Memo.

Date: 13th January 2010
To: Planning
Cc: -
From: Miriam Hill
Subject: S6/2009/2574/FP – Land at Hornbeam Lane (Spike Island), Brookmans Park

Proposed garage & garden store  
 Plan & Elevations

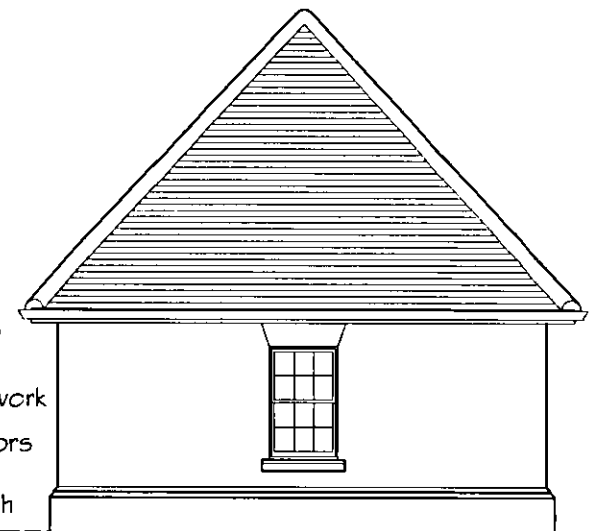
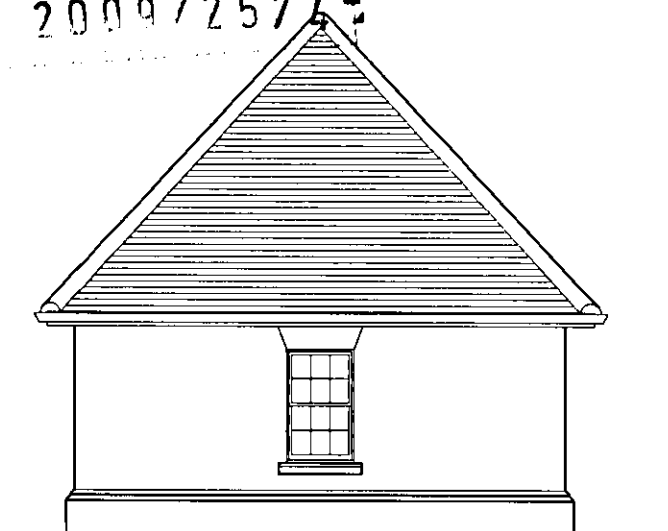
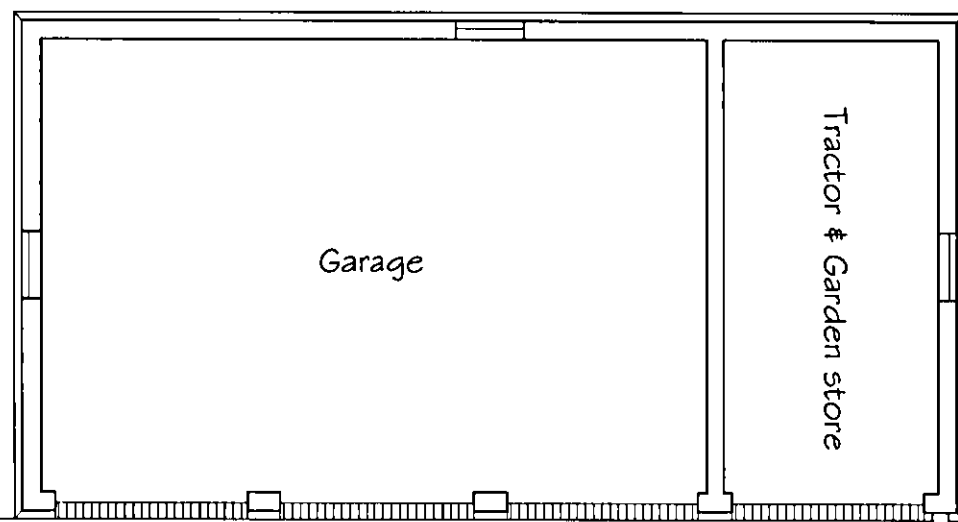
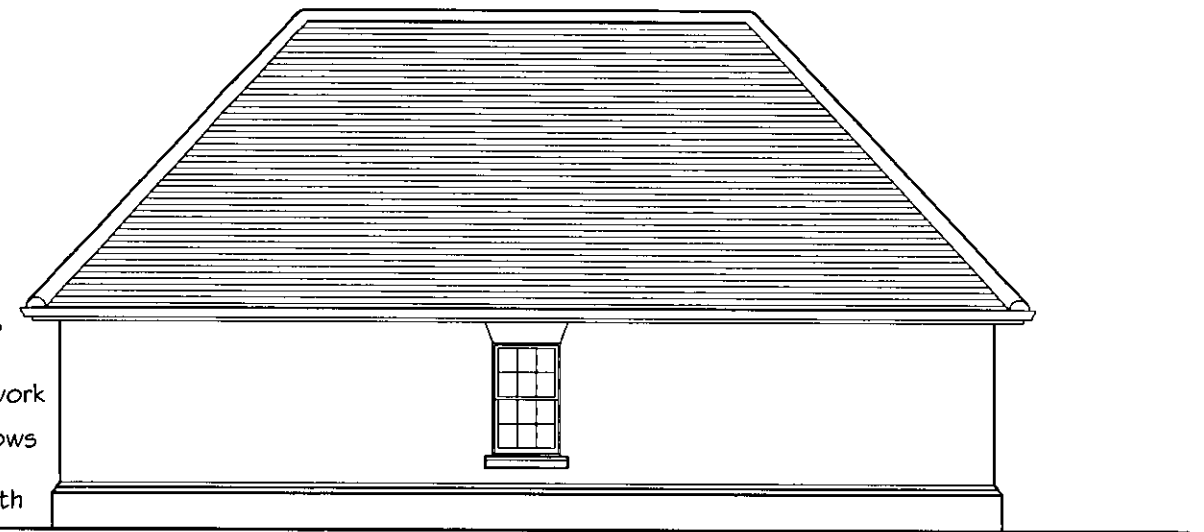
Within the field north-west of the house and in the vicinity of the house the planting becomes more ornamental. The symbols for the specimen and hedgerow trees and the semi-mature specimen trees are virtually indistinguishable, making informed comments more tricky. I was also unsure of the route of the driveway(s). The Landscape Proposal shows one running closely, parallel to the lane, whilst the Site Layout Replacement

Dwelling Garage and Garden Store plan has a second gravel driveway running directly to the front of the house.
